Ribble Valley Borough Council  
Council Offices  
Church Walk,  
Clitheroe  
Lancashire  
BB7 2RA

Phone: 0300 123 6780  
Email: [Kathryn.Walsh@lancashire.gov.uk](mailto:Kathryn.Walsh@lancashire.gov.uk)  
Your ref: 3/2025/0153  
Our ref: 3/2025/0153/HDC/KW  
Date: 18 March 2025

**Location:** Land rear of 8-9 Stoneygate Lane Ribchester PR3 2ZS  
**Proposal:** Proposed stables and manege including tree planting to comply with BNG.  
**Grid Ref:** 364579 437652

Proposed Site Plan

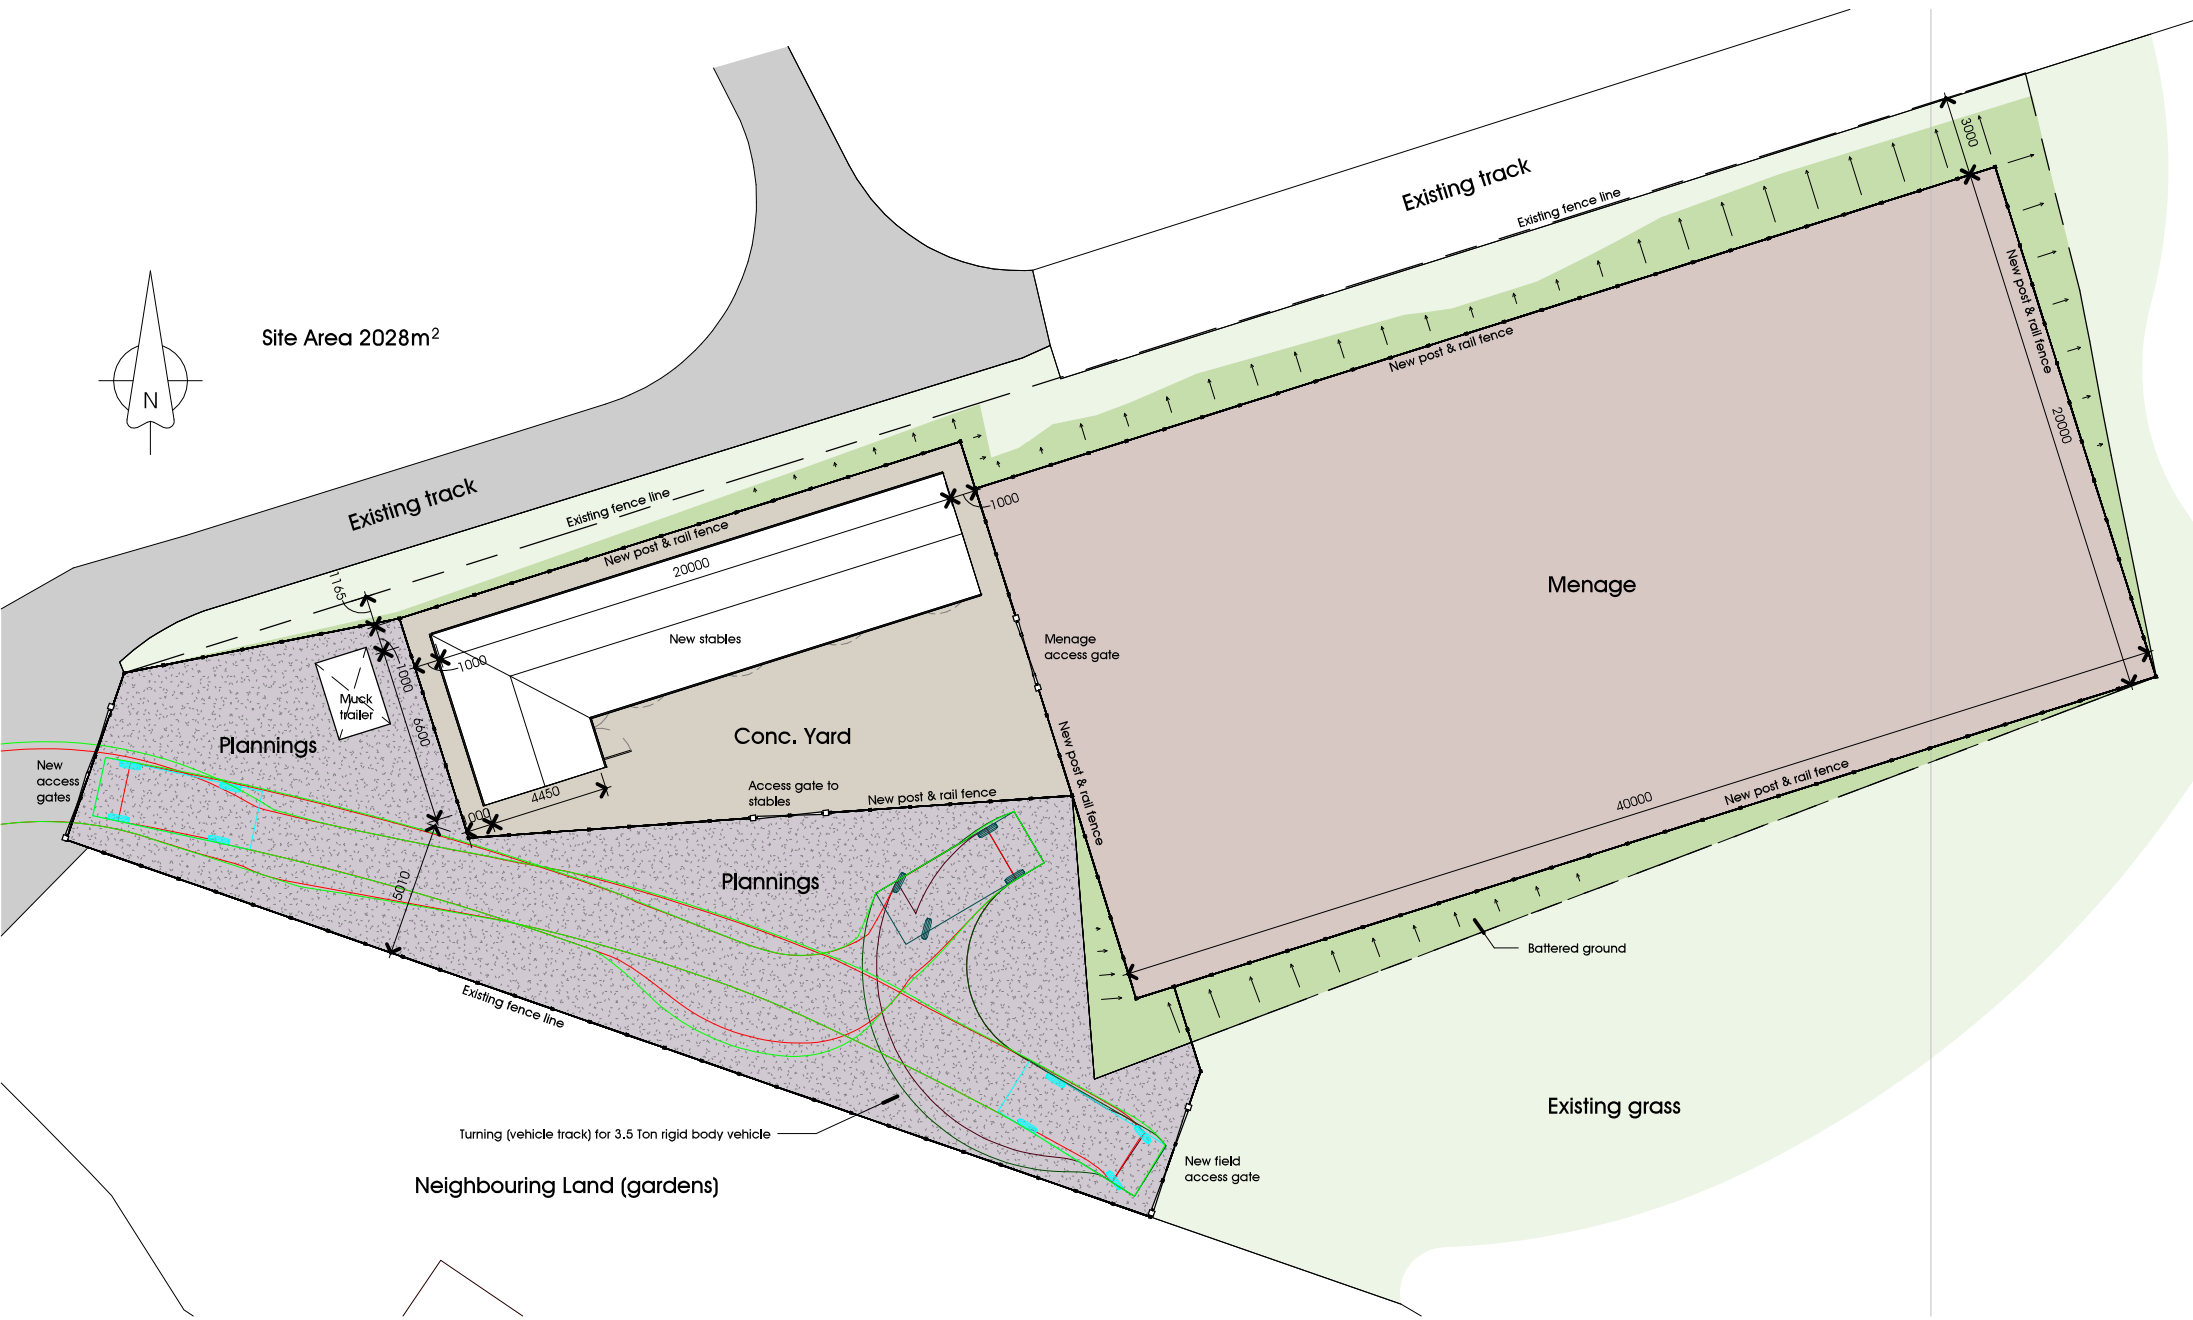
The Applicant has failed to provide a Parking Layout drawing showing that parking can be accommodated on-site. However, a swept path analysis shows that a 3.5-ton ridge body vehicle can turn within the site.

The LHA require a drawing to be submitted by the Applicant showing the Parking Layout of the site, should the Applicant state in their Operational Statement that the proposal will be used commercially. This is so the LHA can determine that the site has adequate parking and will not conflict with the turning provisions shown.
